Consultee Comments for Planning Application

23/02878/DOM

Proposal: Demolition of garage and erection of 1 no. annexe outbuilding.

Name: ?-? Environmental Strategy Unit

# Elevations

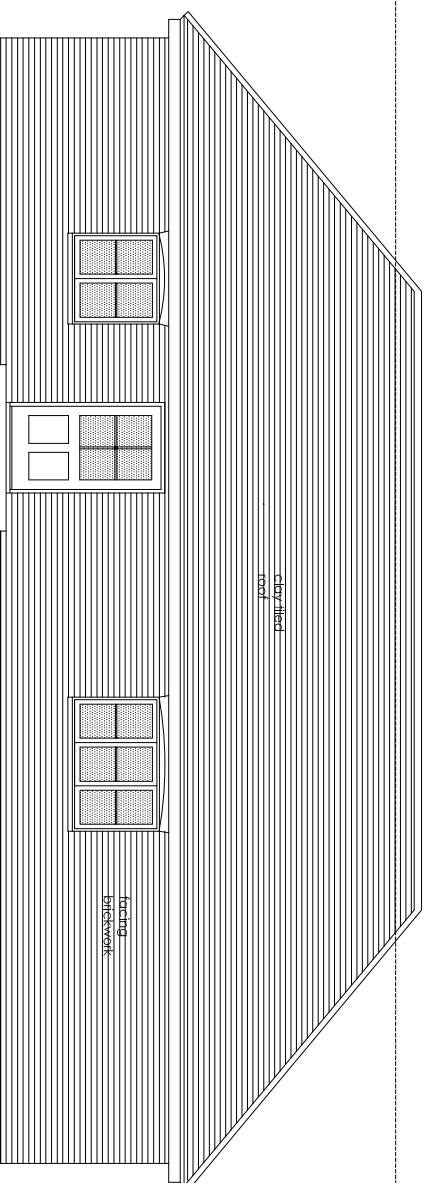
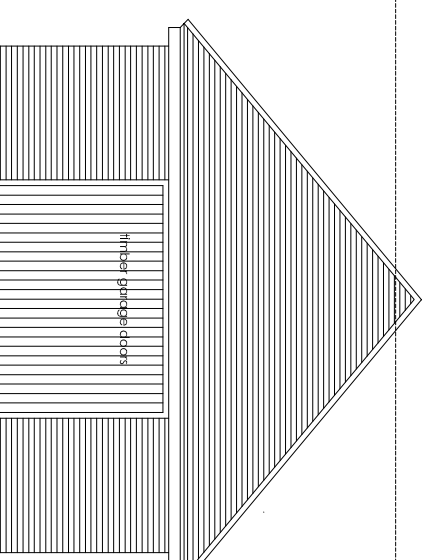
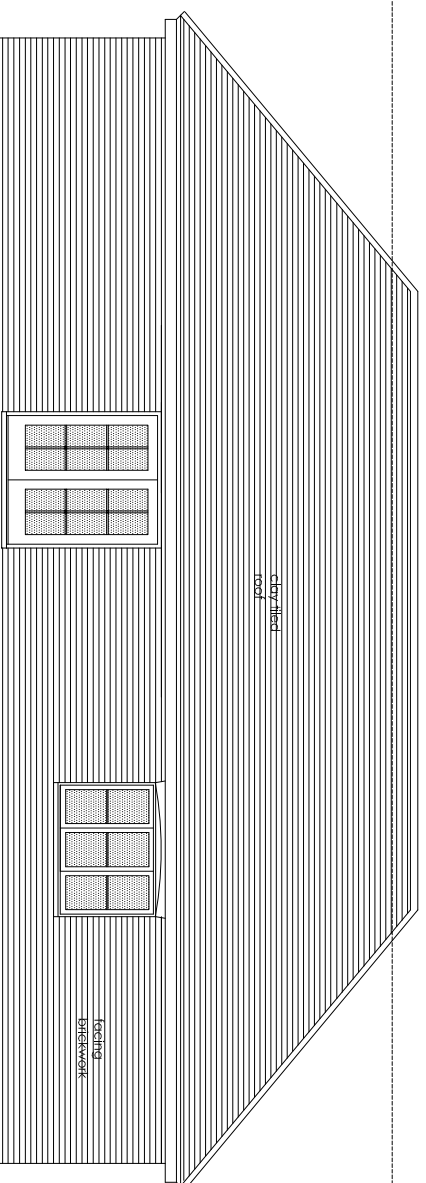
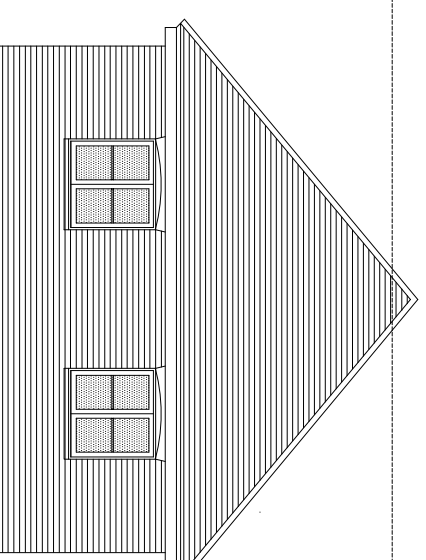
We require that a bat box is installed on the buildings onsite facing south/south westerly positioned 3-5m above ground.

We would like a bird box to be installed on the building / and or tree within the garden of the property.
